National Highways Planning Response (NHPR 21-09) Formal Recommendation to an Application for Planning Permission

Council's Reference: 21/03268/OUT

Location: OS Parcel 2636, NW of Baynards House, Ardley

National Highways Ref: 92859

Section 1-1 (1:250 @A1)

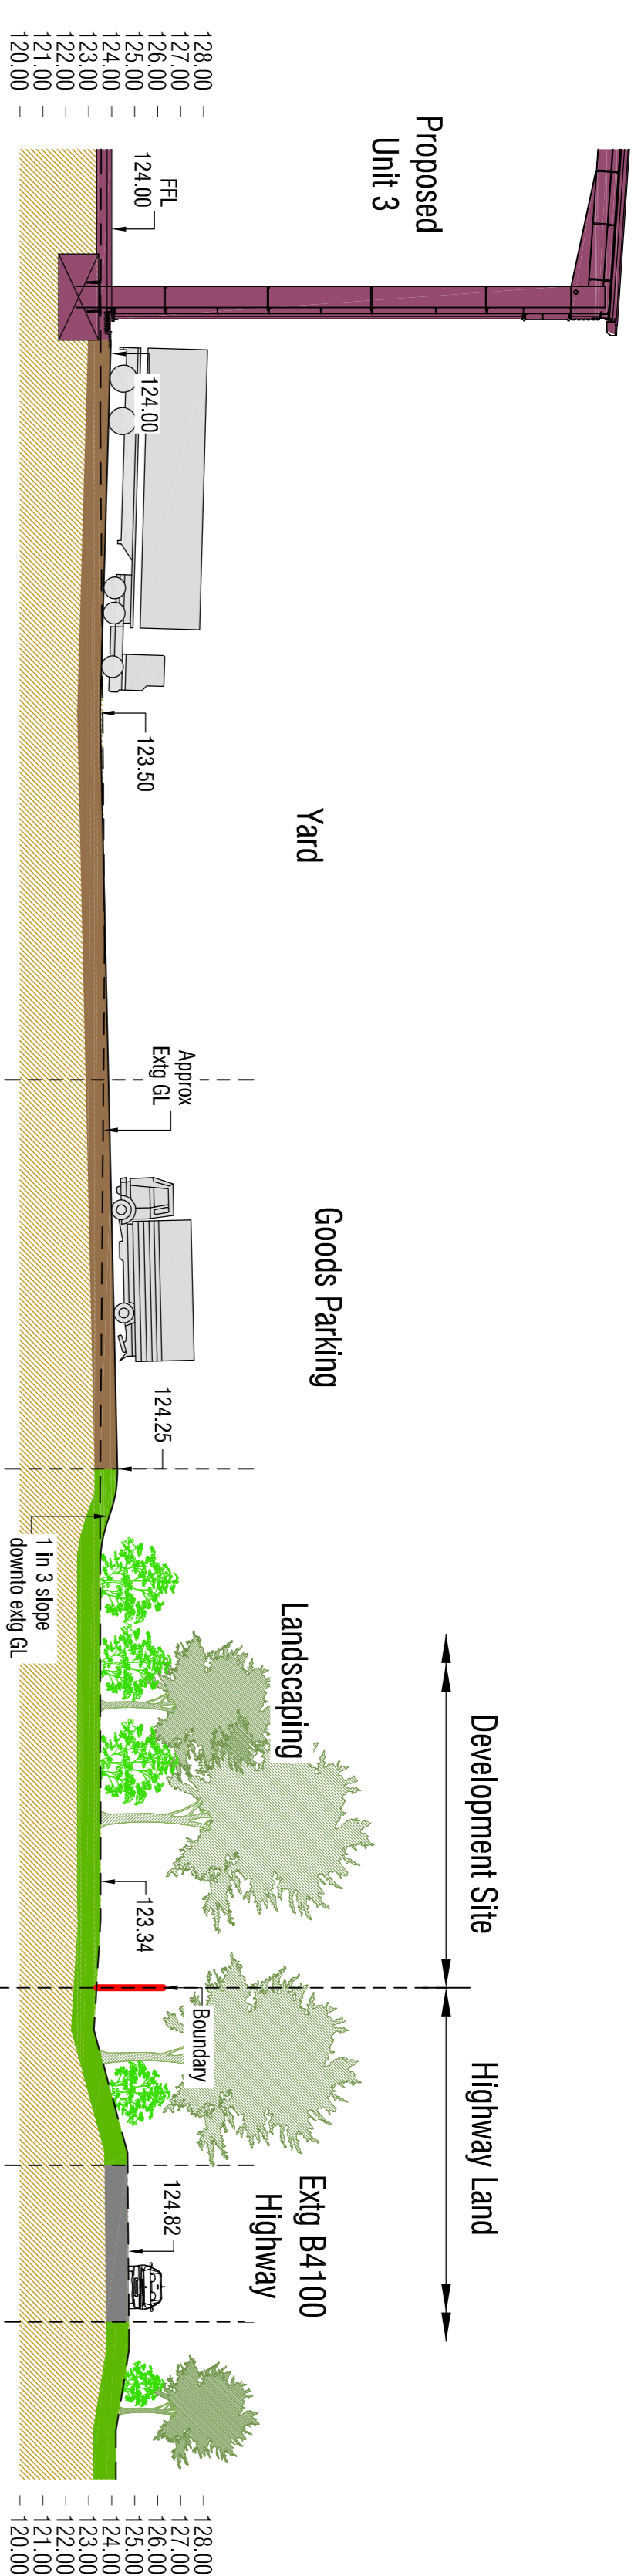
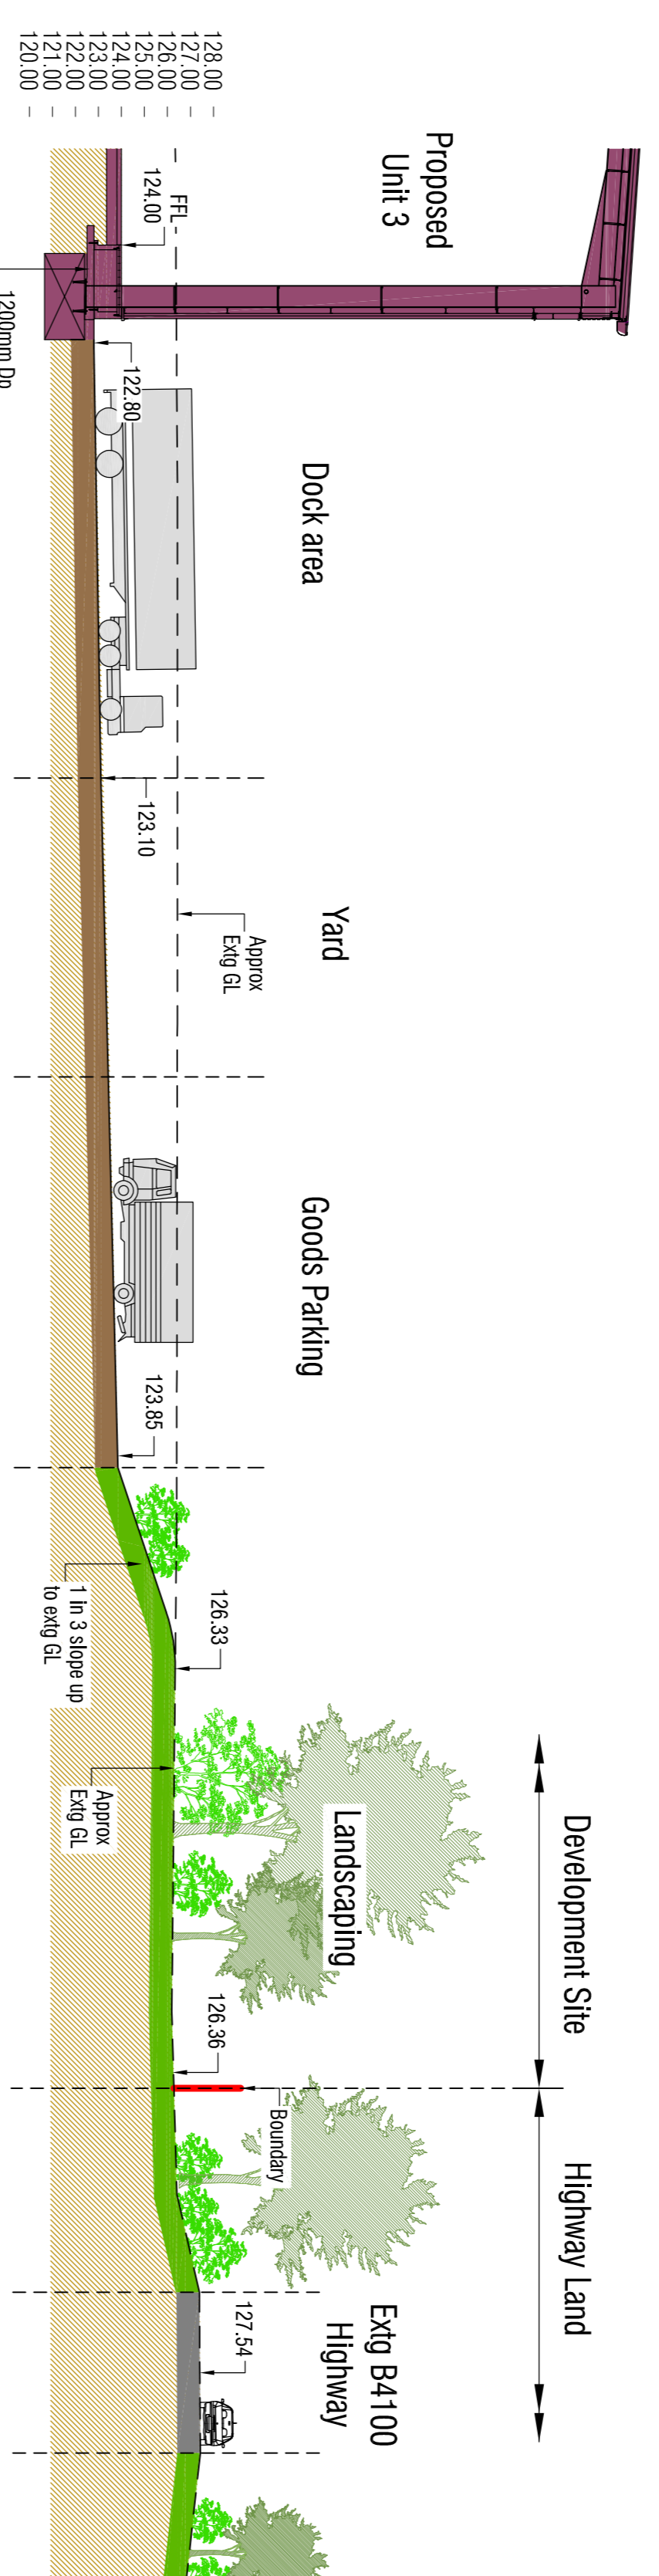
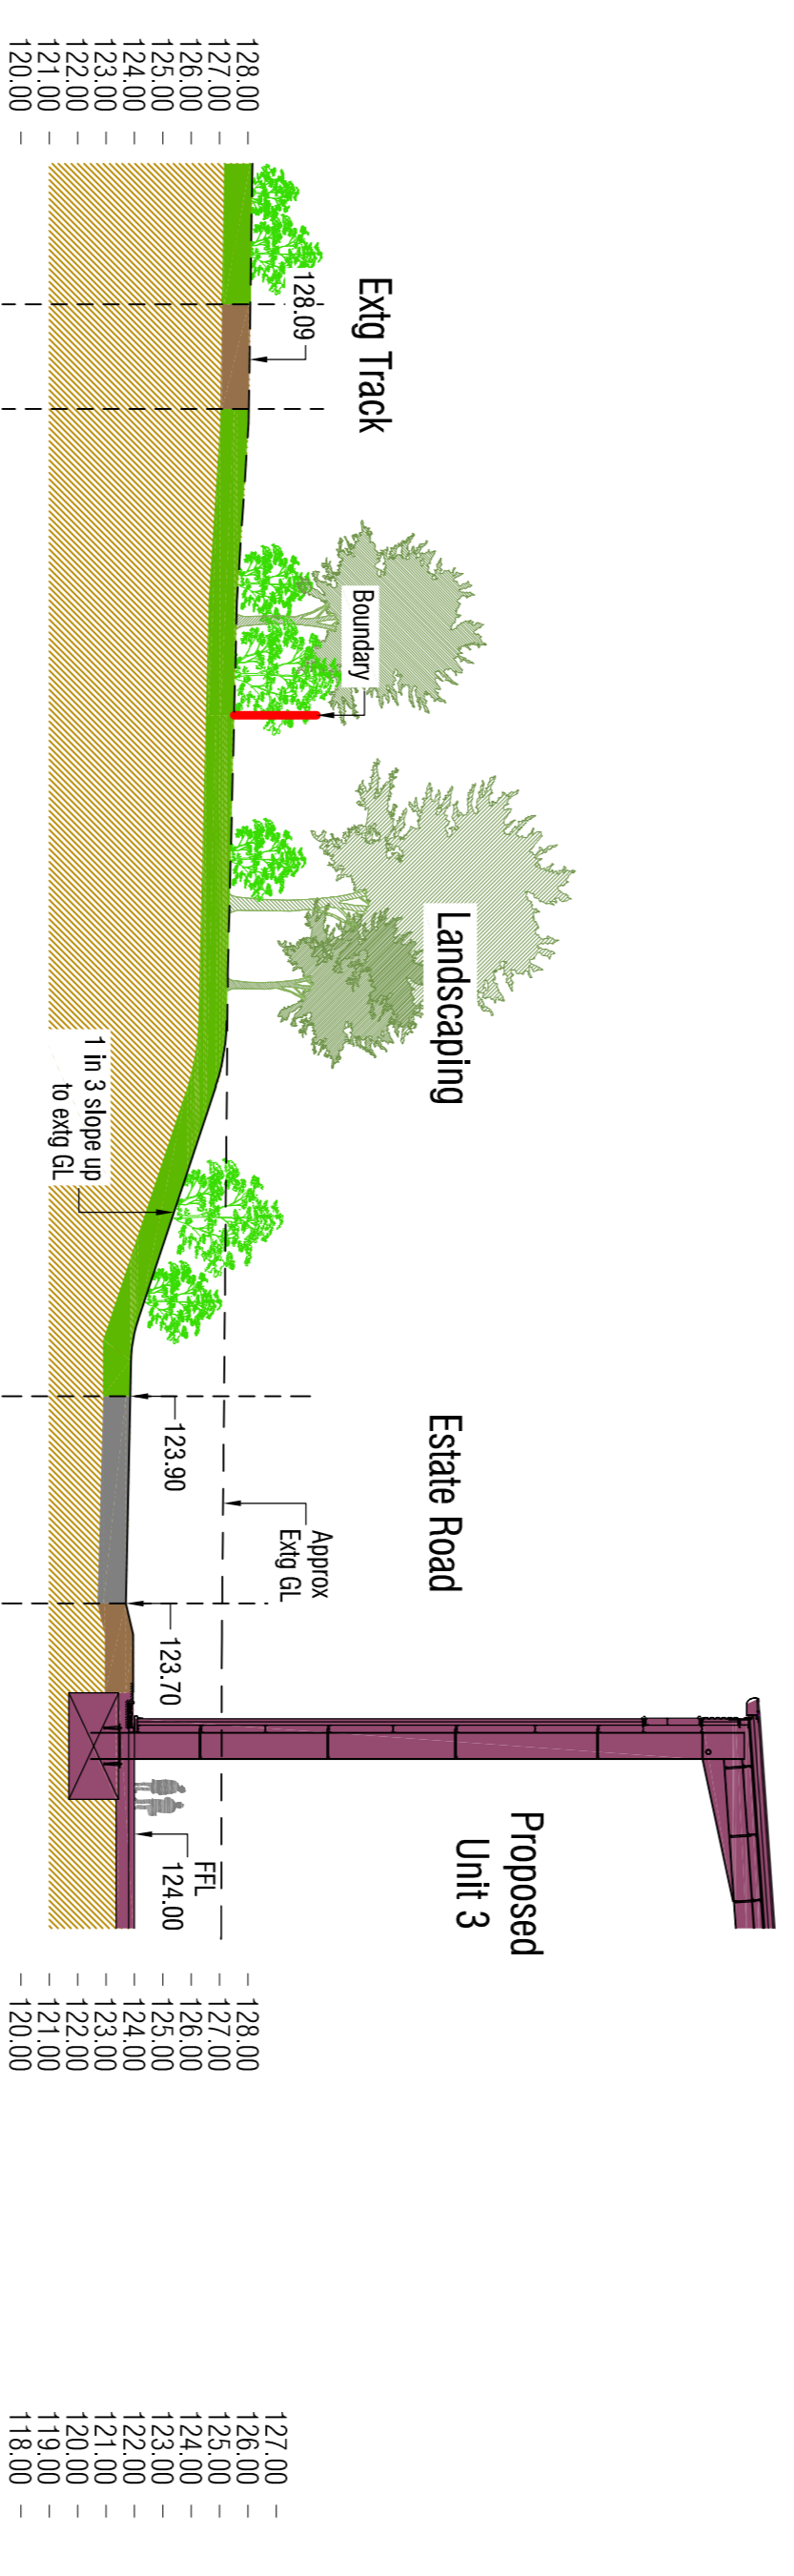
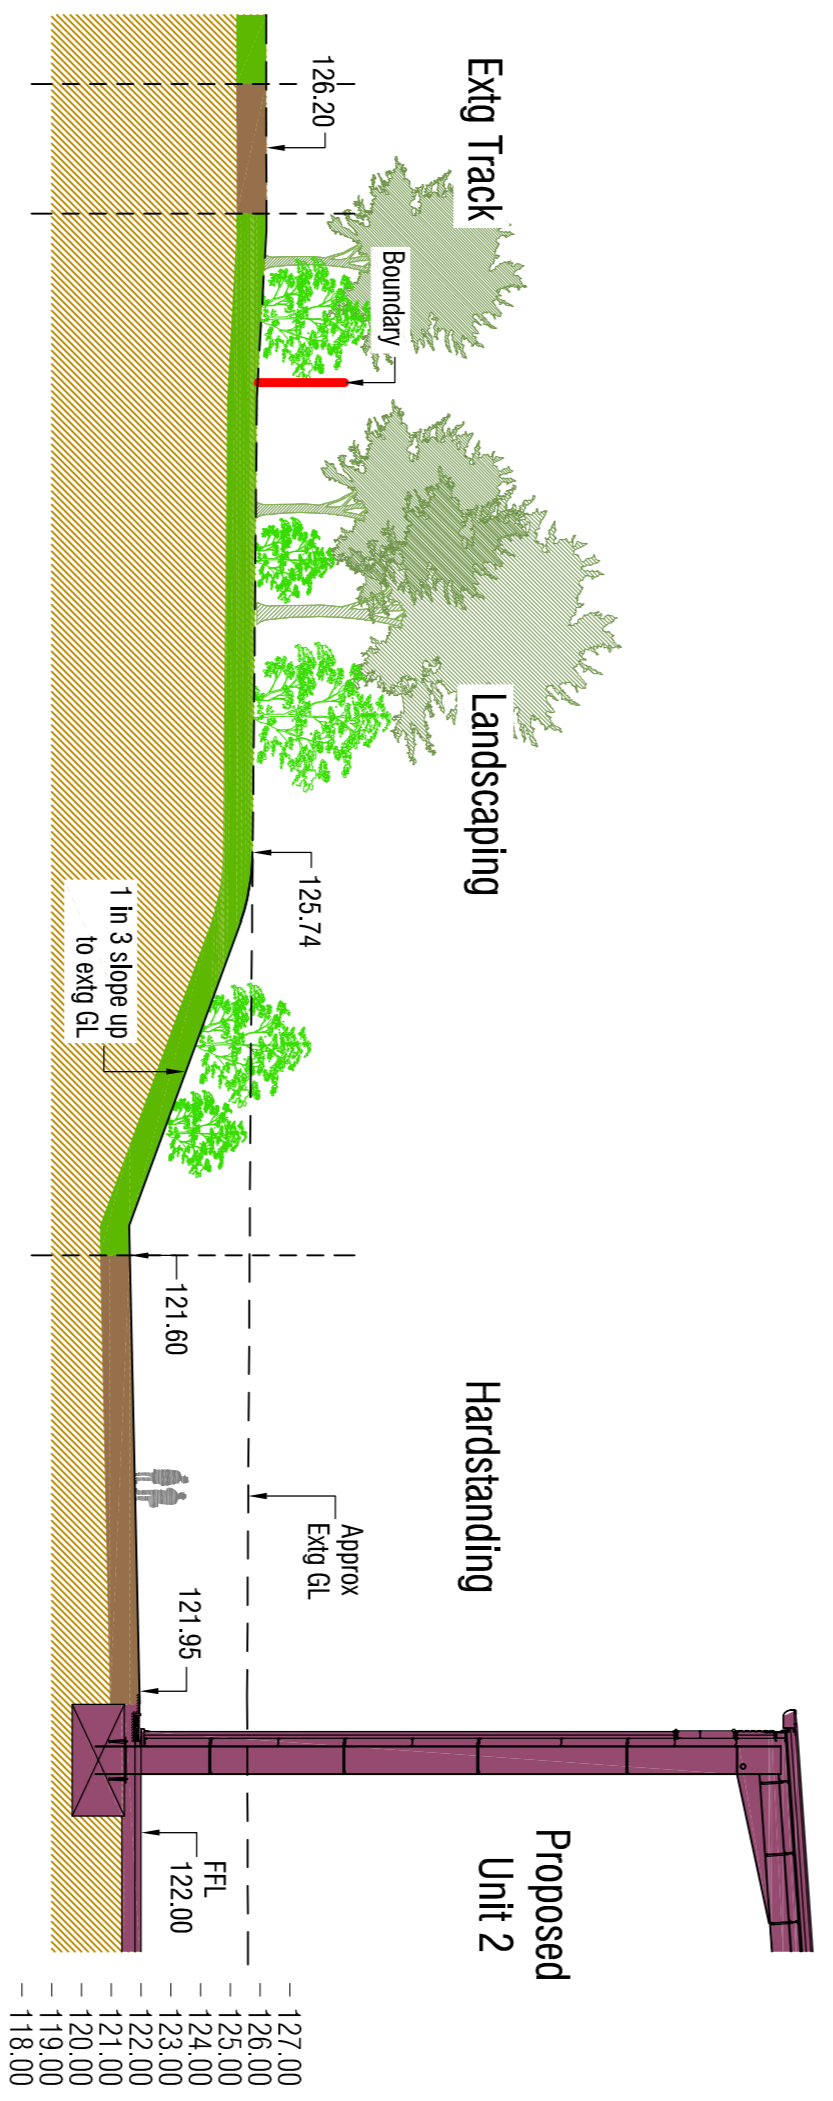
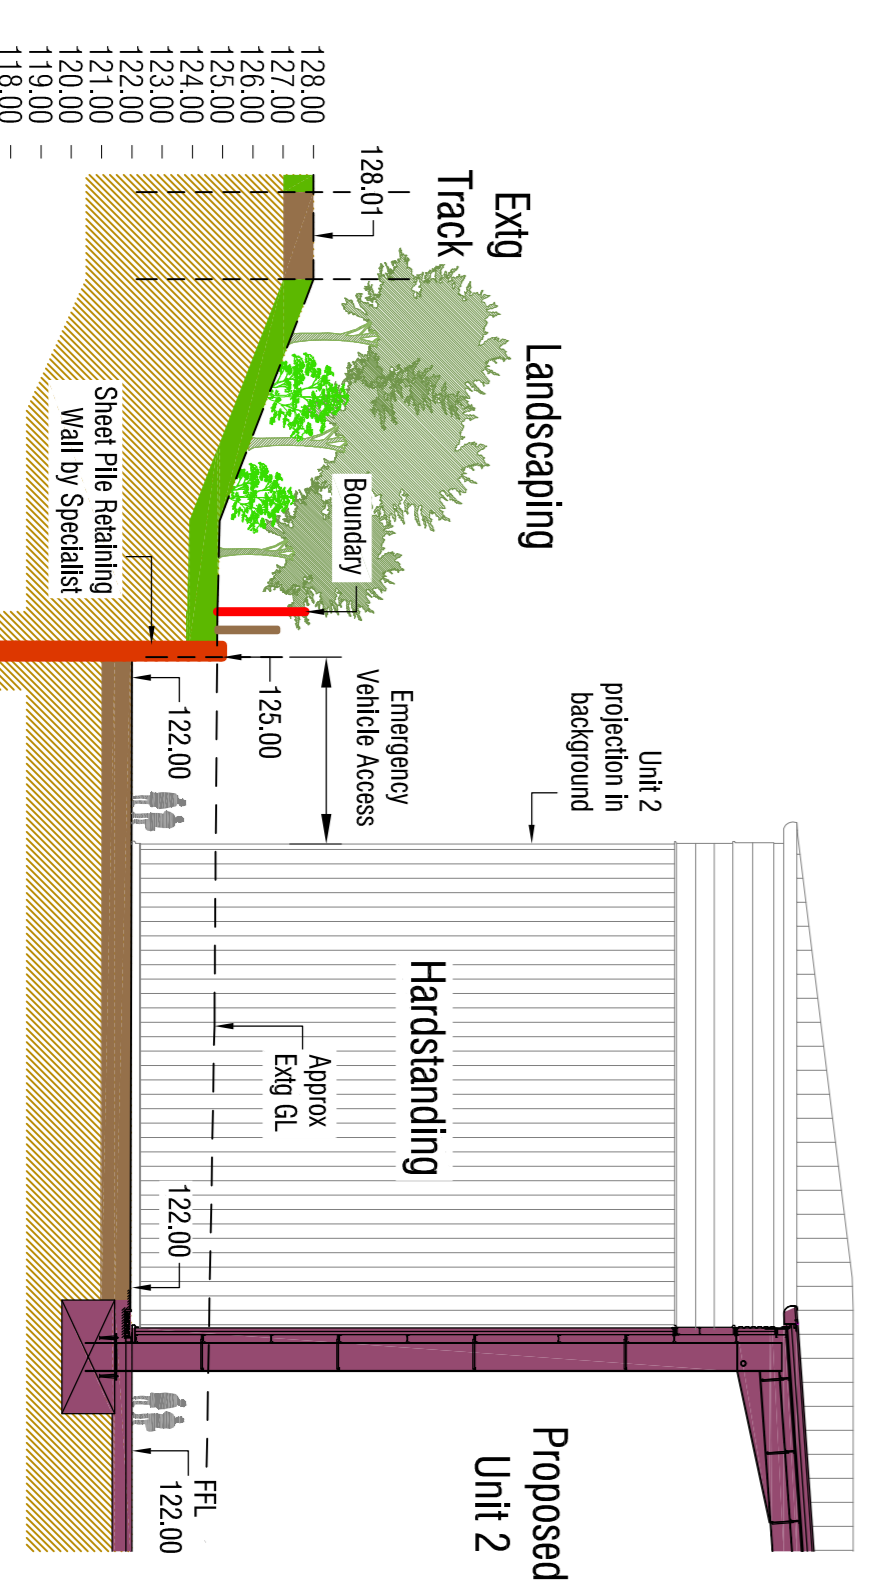
The applicant will need to advise / confirm if there will be any earthworks associated with the development(s) in relatively close proximity to National Highways boundaries (e.g. the stability of the balancing ponds, etc). In the first instance, some cross sections (to scale) through the boundaries showing the proposed extent of the development, its features and any proposed changes in elevation (excavations, landscaping) etc should be submitted for further assessment. Once received, we will review to determine the possible extent of any geotechnical reporting under the Design Manual for Roads and Bridges (DMRB) standard CD 622, which may be required to confirm the extent of any geotechnical risk to the SRN.
